Application No: BE/59/21/PL
Site Address: 339 Chichester Road Bersted PO21 5AN
Description of works: Replacement of blockwork boundary wall with fence and new vehicular access (resubmission of BE/149/21/PL).

Thank you for your internet representation made on 3rd June 2021 which has been recorded as an objection with the comments as follows:

SITE PLAN - SHOWING VISIBILITY SPLAYS
1:500 SCALE (at A3)

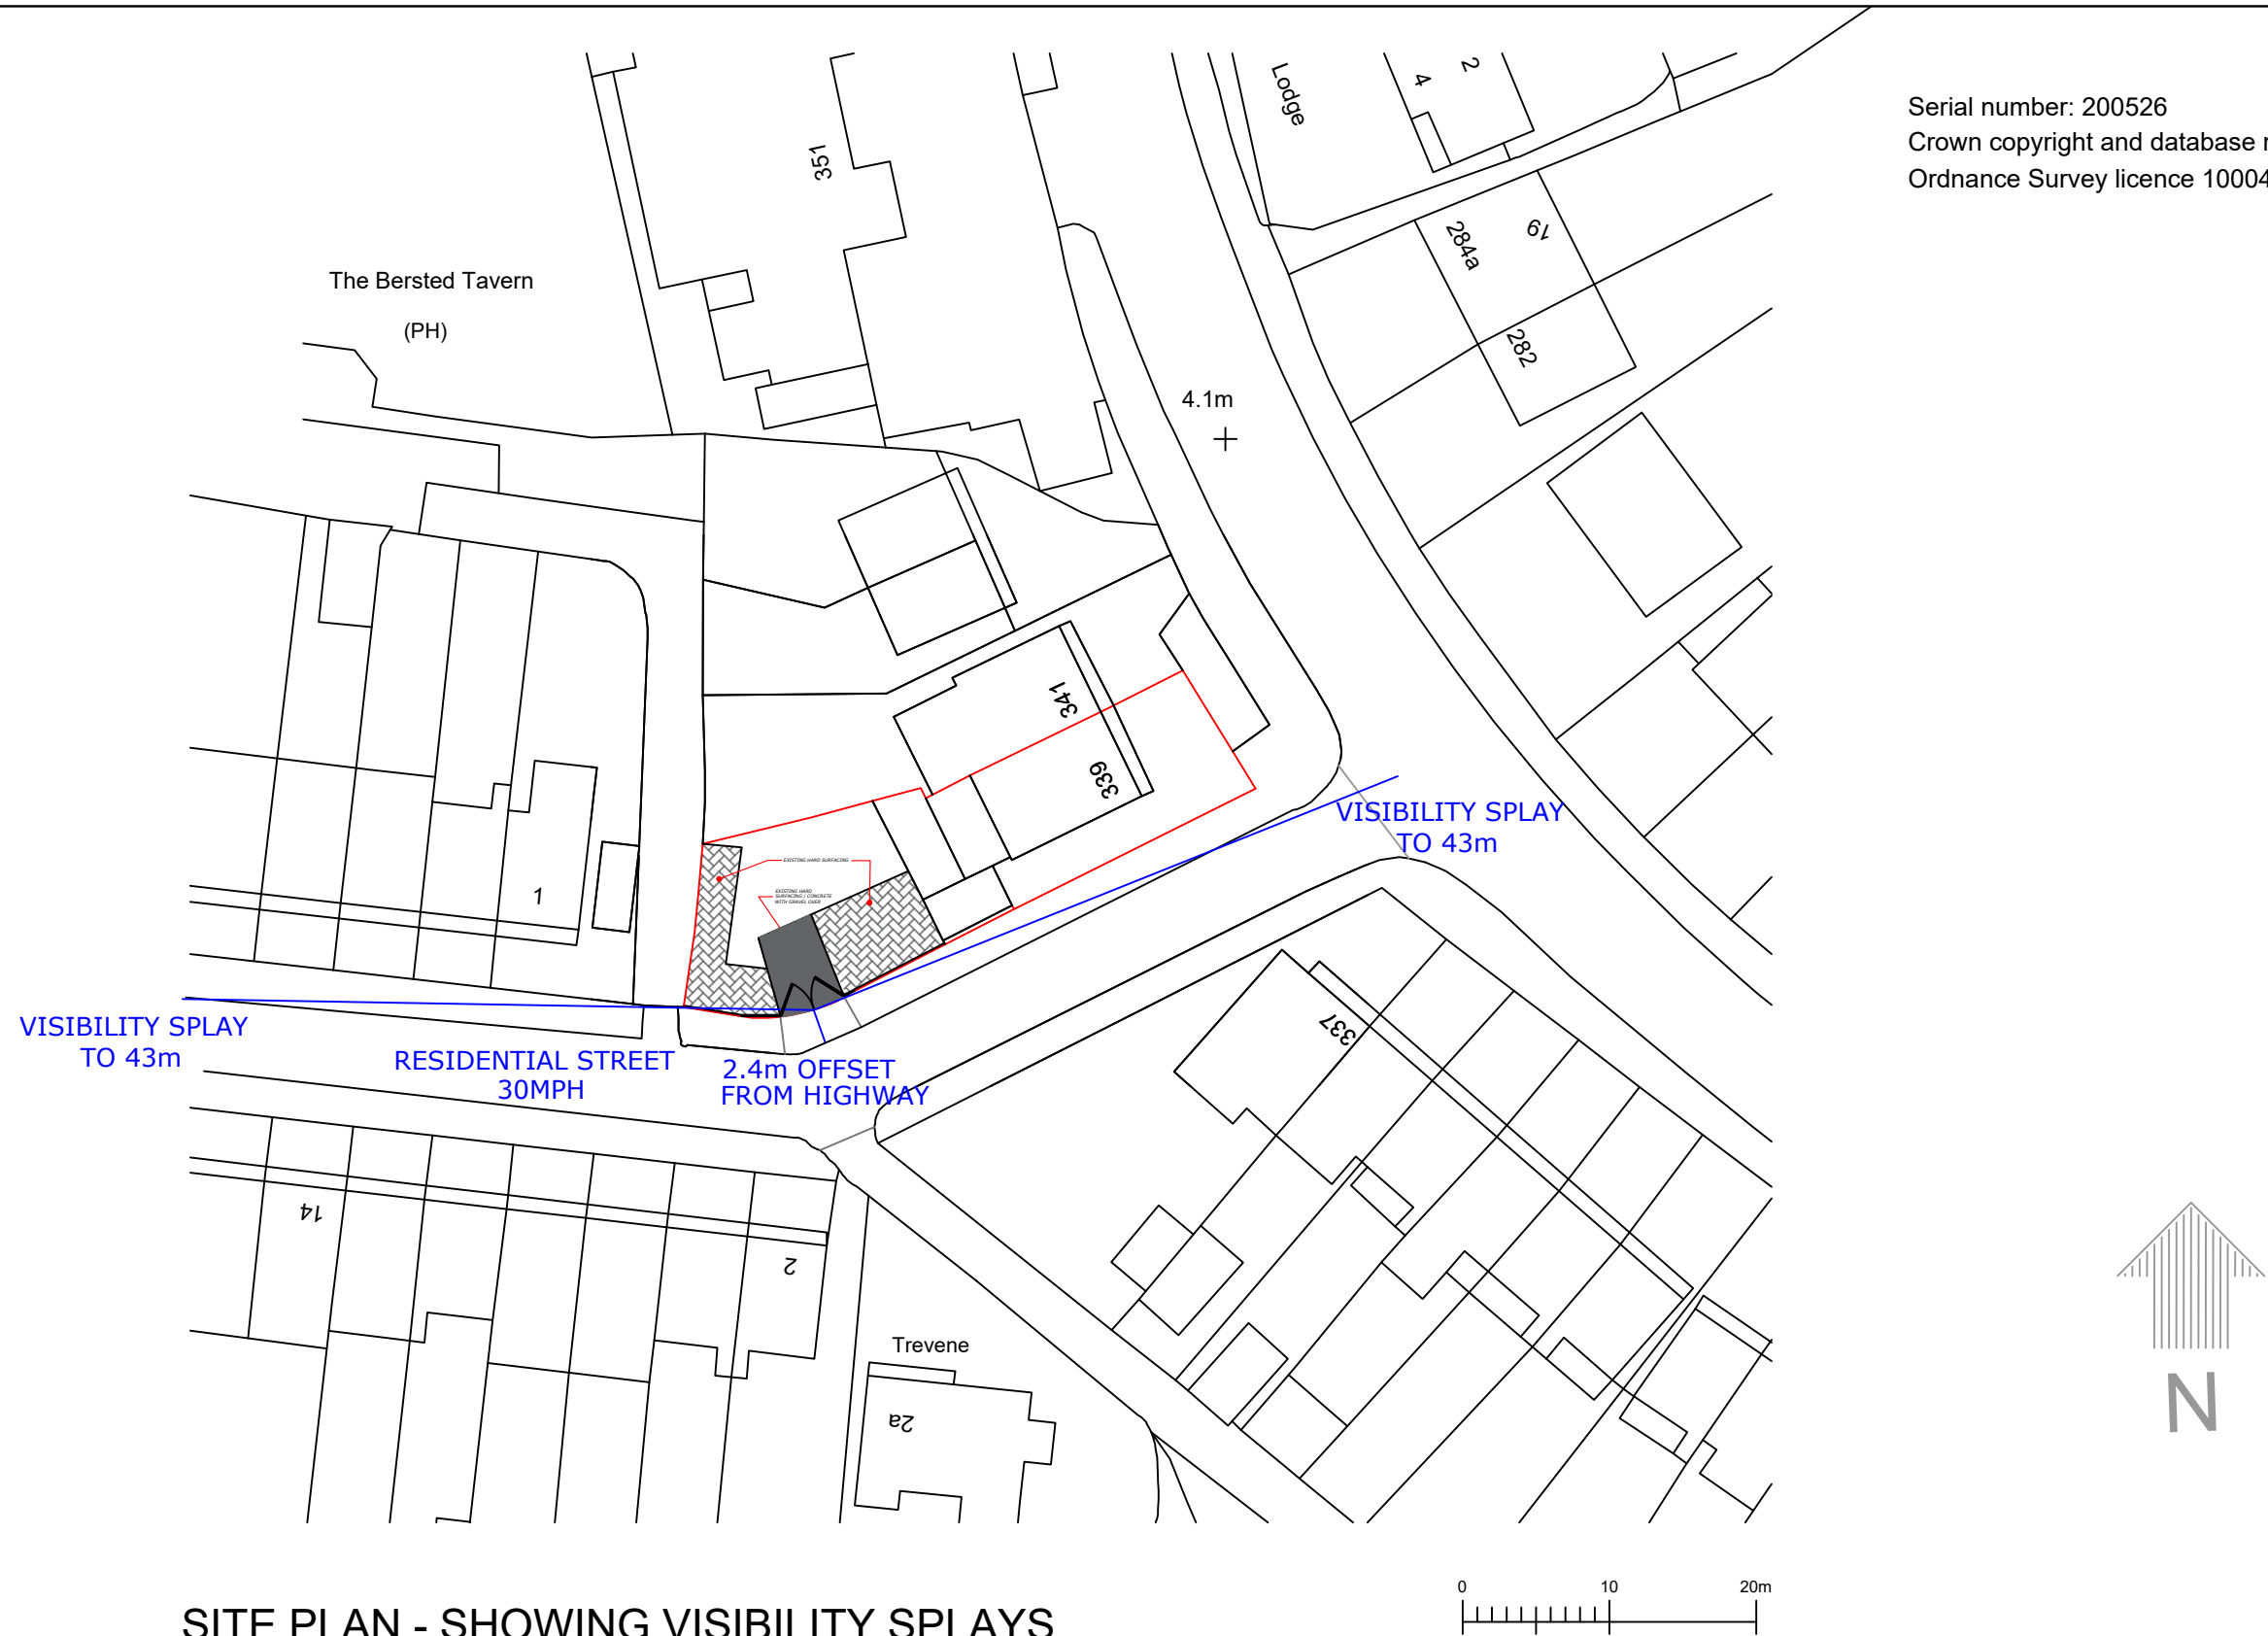
This is a well known dangerous corner where previously bollards were placed to control traffic. Delaney already uses this back area for storage of his plumbing business and vans coming in and out from that driveway will be very dangerous. Exiting using this dropped curb does not give adequate visibility. This is a residential area not commercial.
